**Application by Norfolk Boreas Limited for the Norfolk Boreas Offshore Windfarm.
The Examining Authority's written questions and requests for information (ExQ2)
Issued on 12 February 2020**

Norfolk County Council Responses

**Application by Norfolk Boreas Limited for the Norfolk Boreas
Offshore Windfarm
The Examining Authority's further written questions and requests for
information (ExQ2) Issued on 12 February 2020**

CAWSTON HIGH STREET - INTERVENTION SCHEME  
Scale 1:500

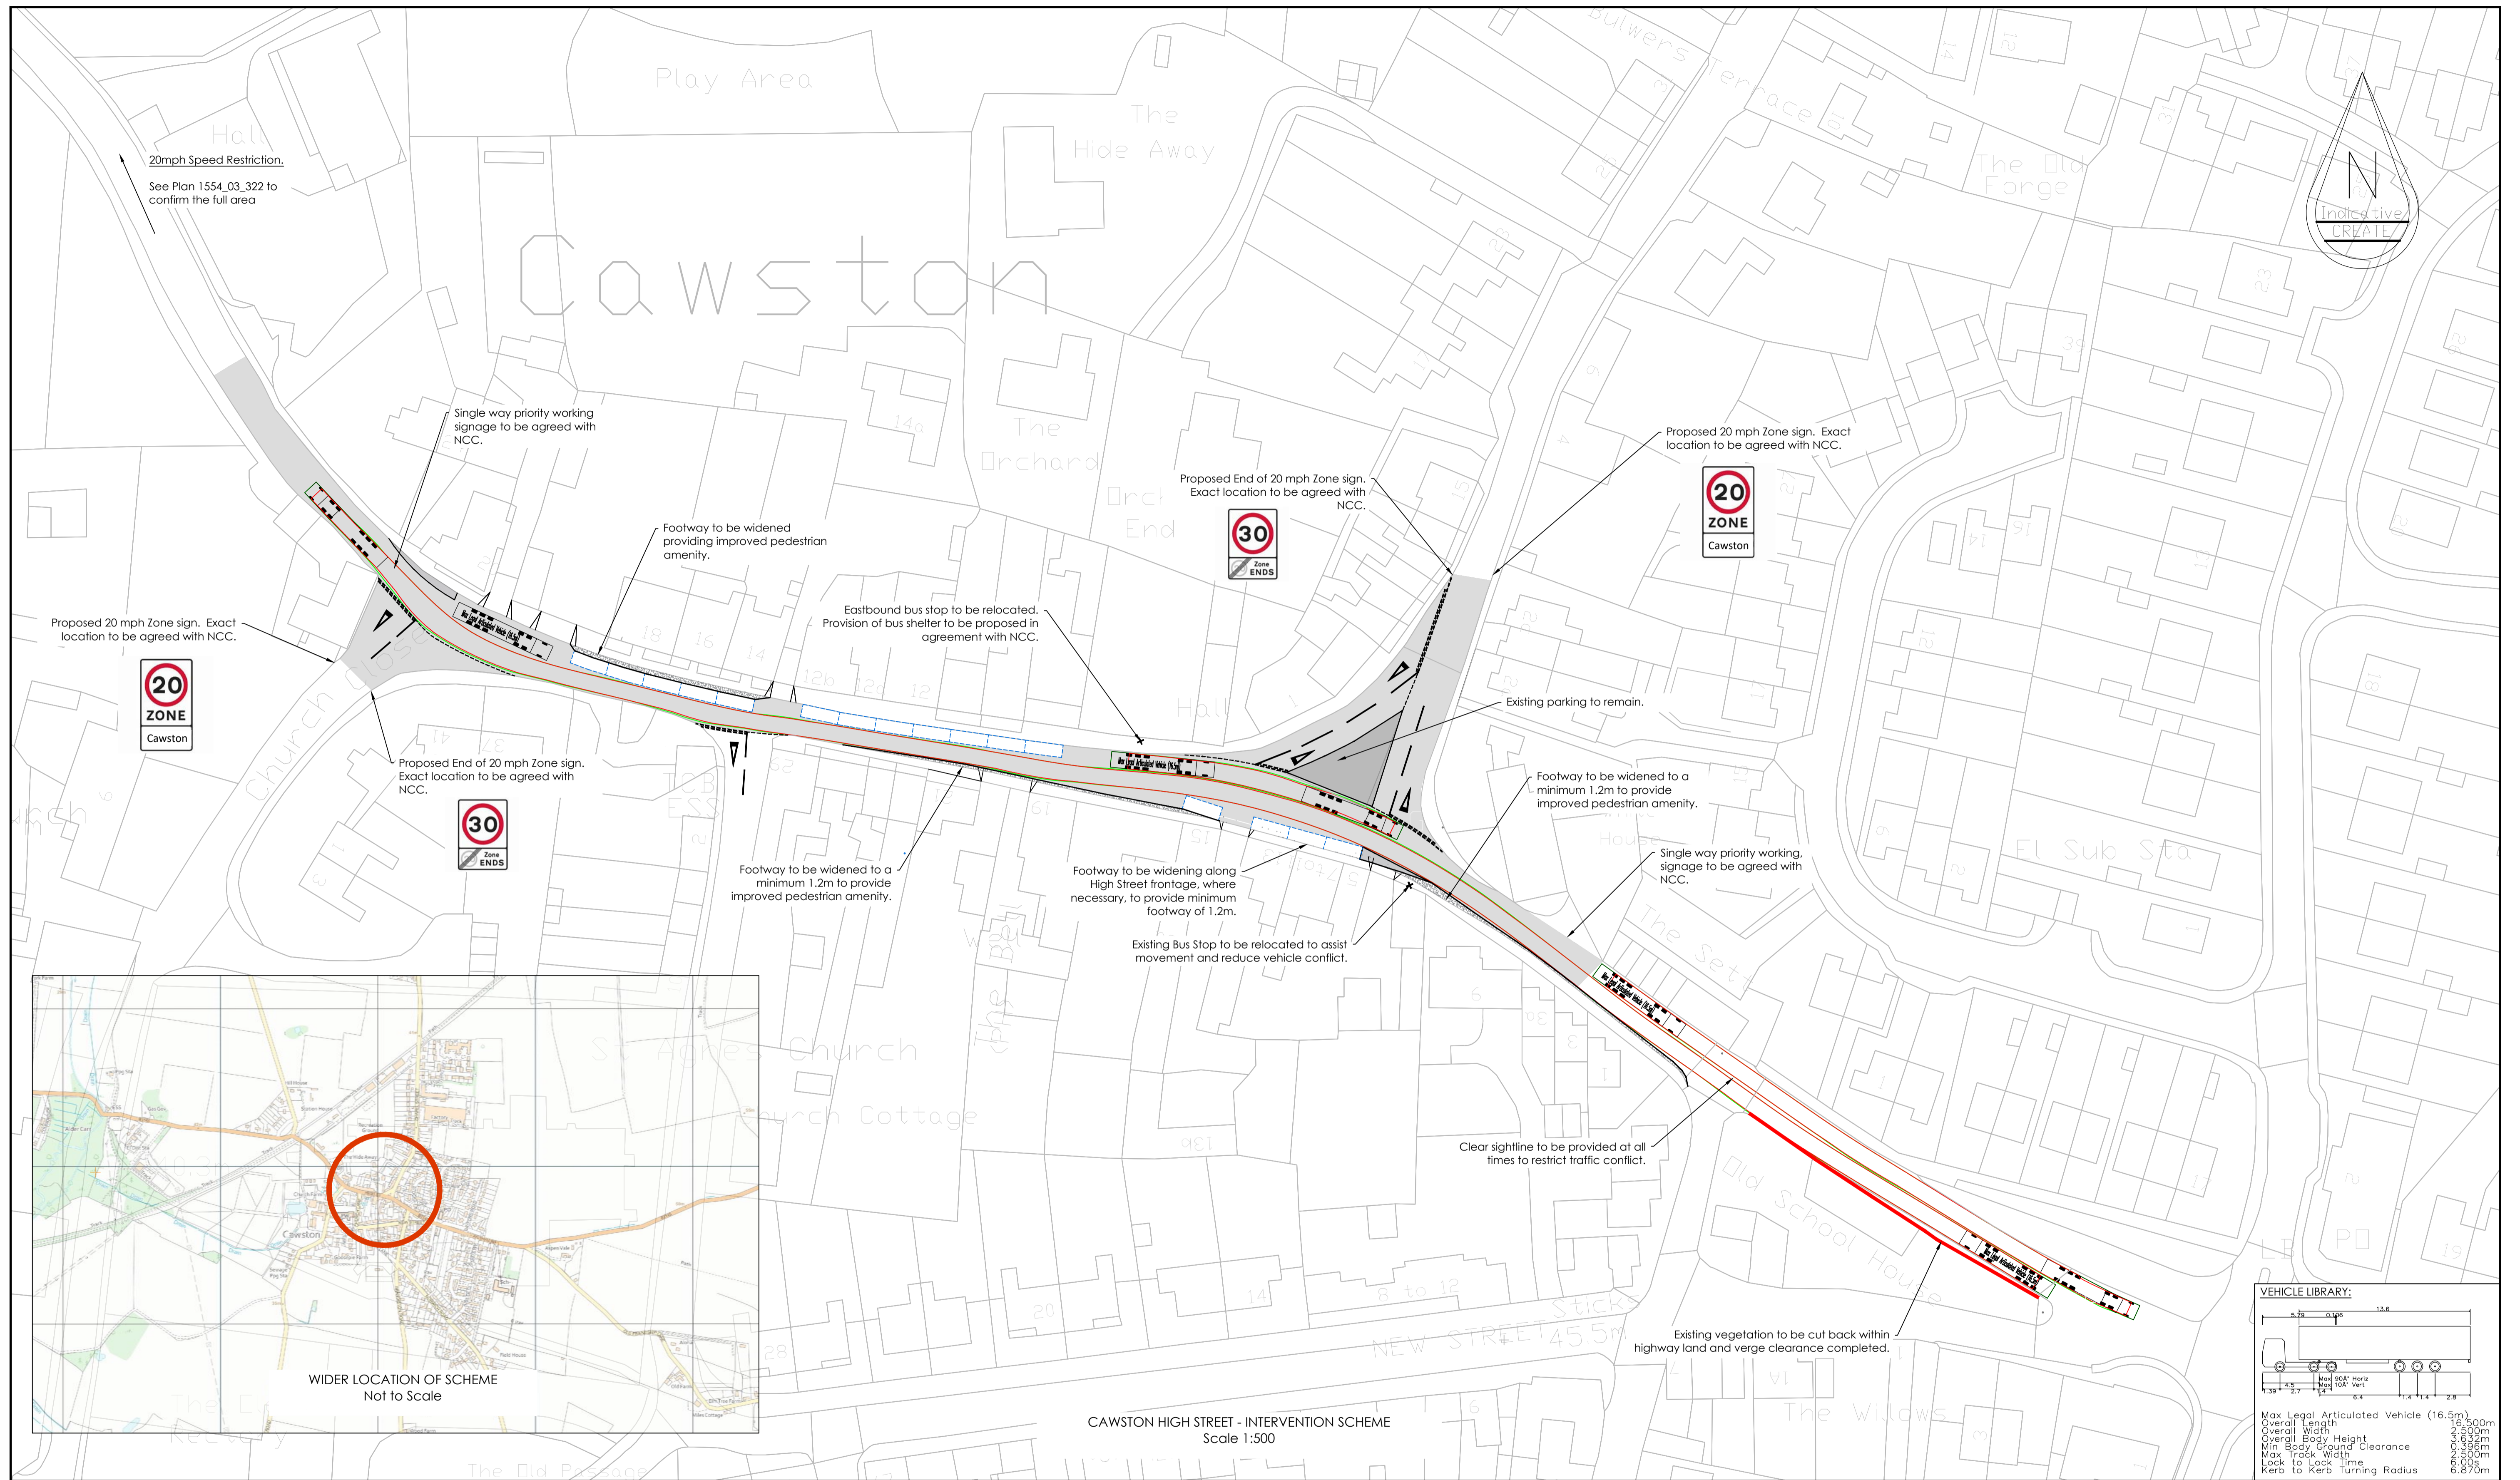
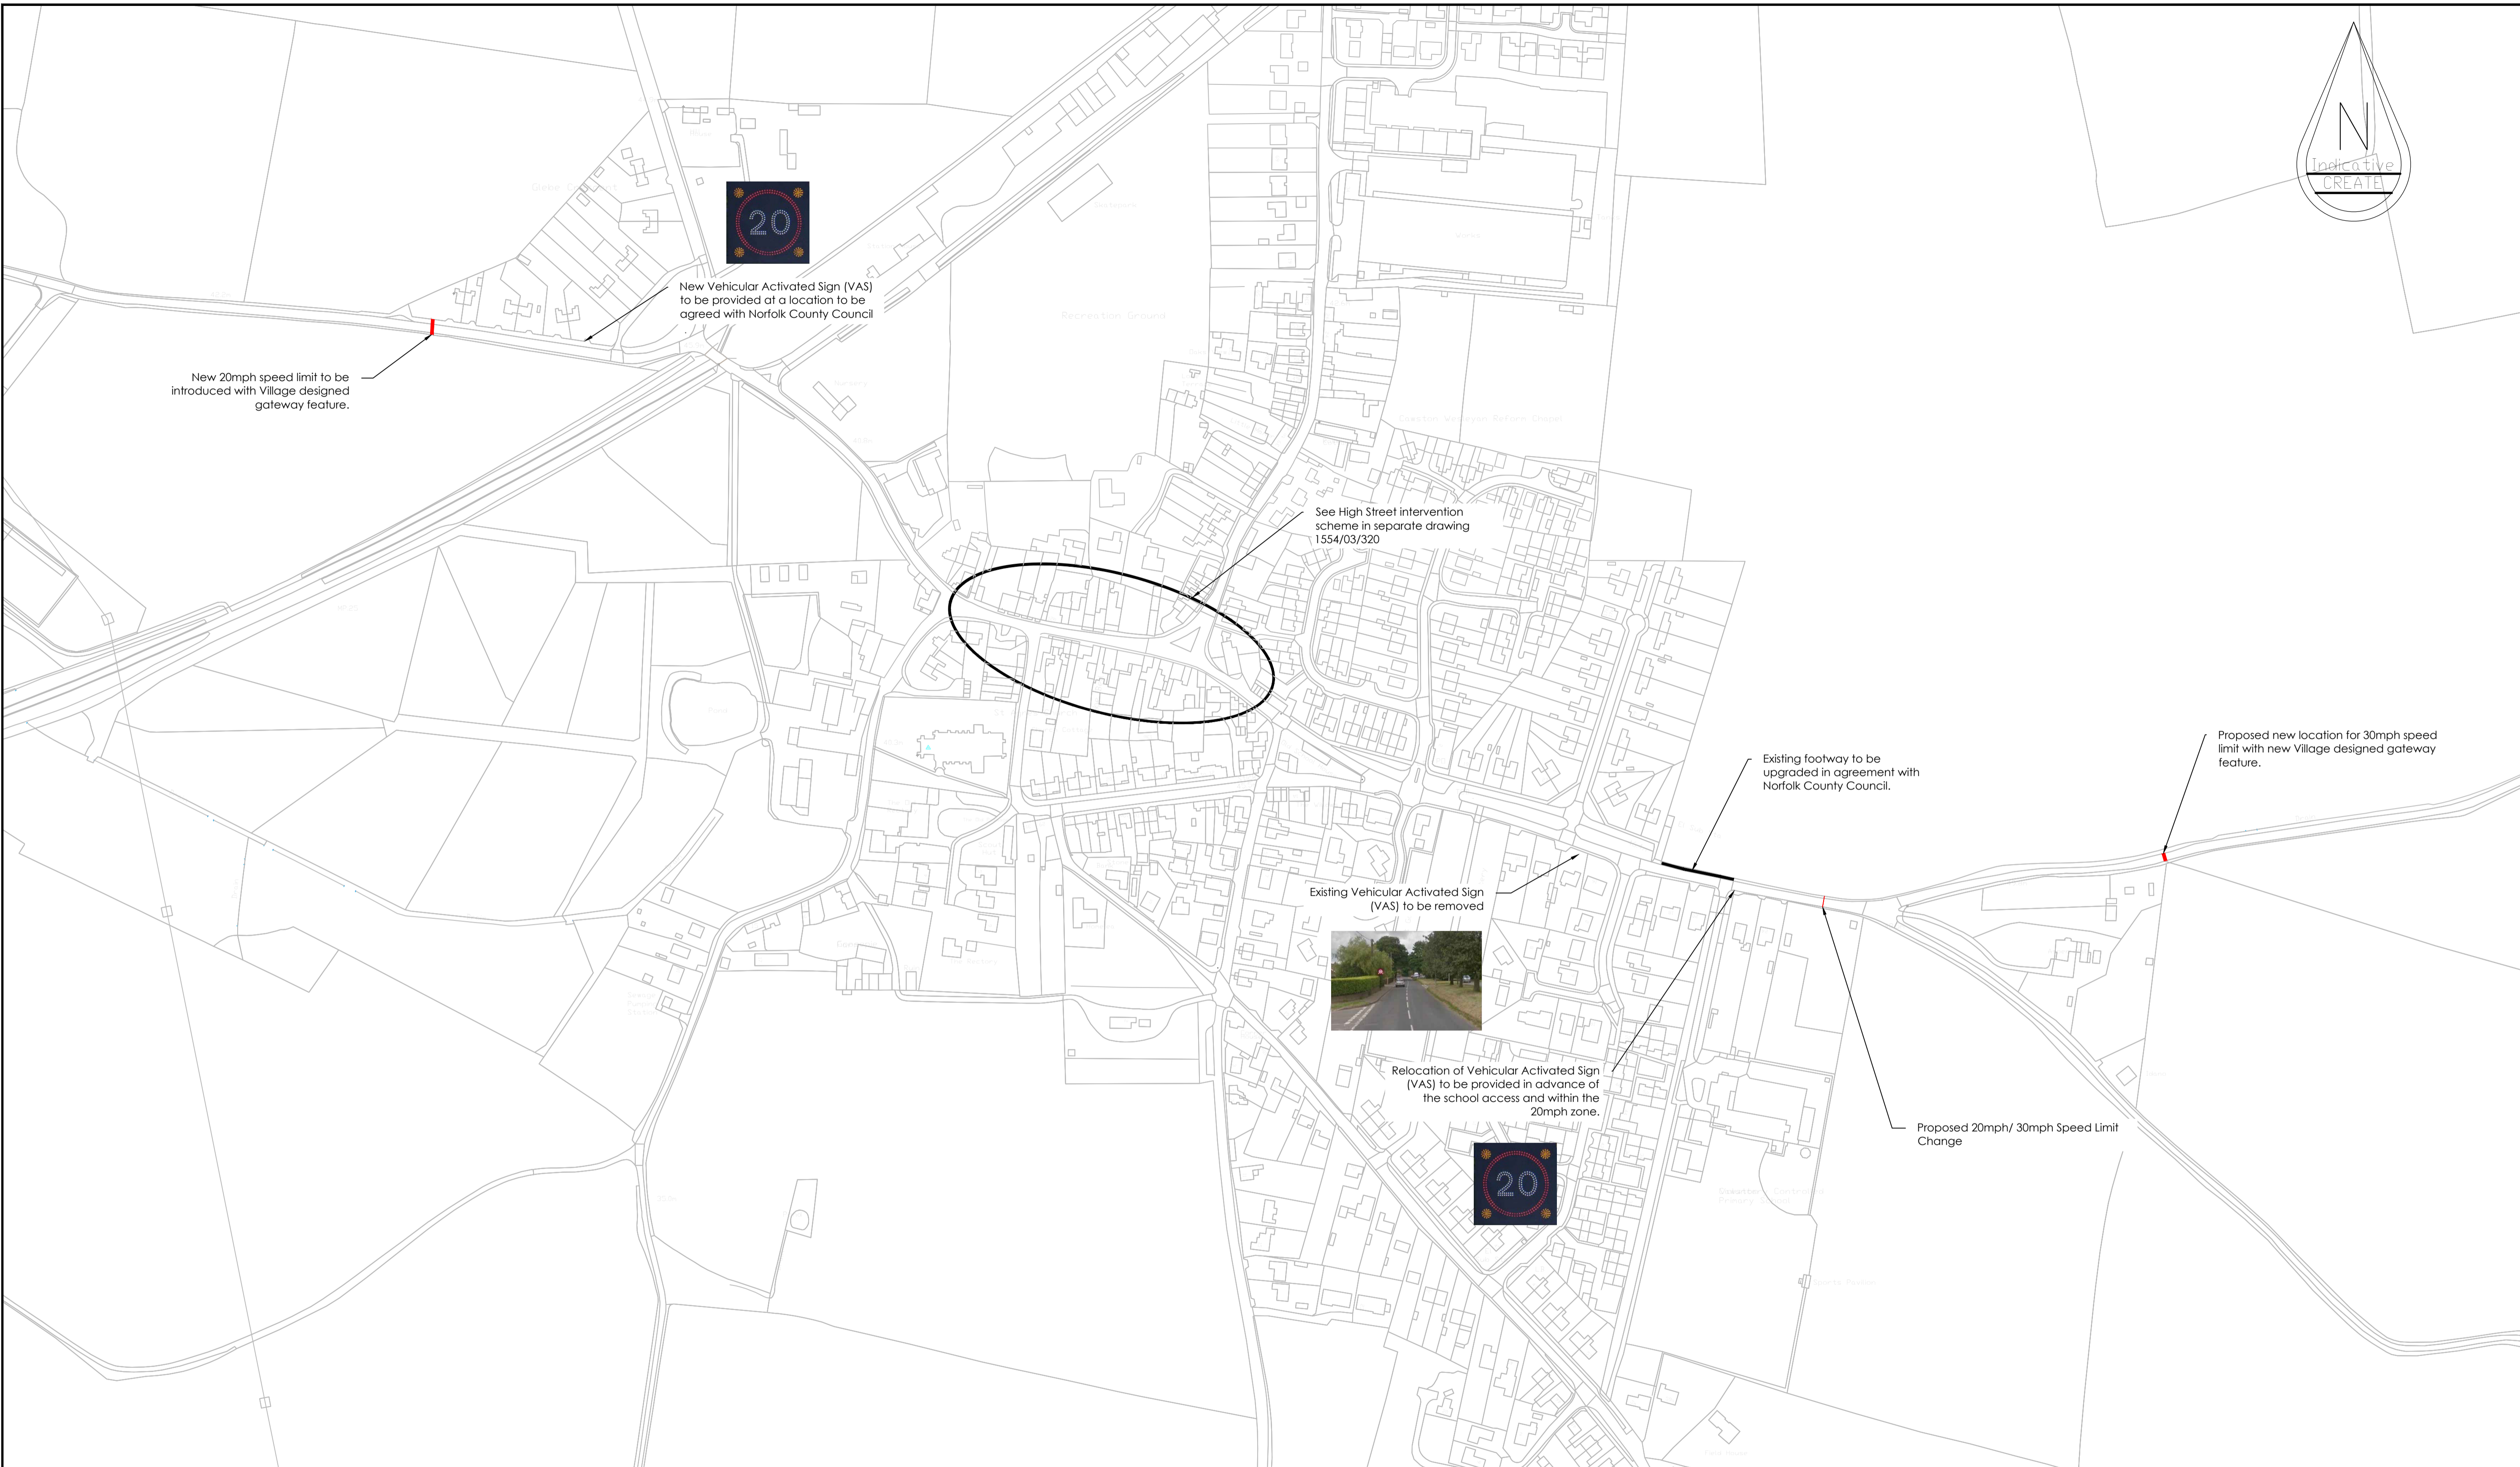
Q.2.14.1.5	The Applicant Norfolk County Council Broadland District Council Cawston Parish Council	<p>Cumulative traffic effects in Cawston: The Secretary of State's letter [REP3-012, paragraphs 15 and 16] regarding the Norfolk Vanguard scheme, states that the highway mitigations for B1145 Cawston link 34 would not be "sufficient to offset any potential harm from in-combination traffic effects arising from the proposed Norfolk Vanguard project and Hornsea Three in the event that both were granted development consent".</p>	<p>We have received revised drawings from the applicants which are broadly in line with our expectations. However, we have not yet received an updated road safety audit (RSA) from the applicants.</p> <p>We understand that an updated RSA was due to be submitted to the applicants by their</p>

<p>1. Do all parties agree that the revised Highway Intervention Scheme [REP4-016] would mitigate the cumulative effects of the Proposed Development Scenario 1 (Norfolk Vanguard and Norfolk Boreas) and Hornsea Project Three?</p> <p>2. Applicant to confirm that if Hornsea Project Three is not given consent, how is the Highway Intervention Scheme secured in the dDCO?</p>	<p>auditors on 14 February 2020, but we have not yet been provided with a copy.</p> <p>Until such time as an acceptable RSA is received, we cannot agree that a suitable mitigation scheme exists.</p>
Q2.14.1.7	The Applicant Norfolk County Council Broadland District Council Cawston Parish Council	Traffic movements in Cawston The Position Statement [REP4-020] to be submitted at Deadline 5 to include a list of all matters that are not yet agreed.	To be submitted at deadline 5
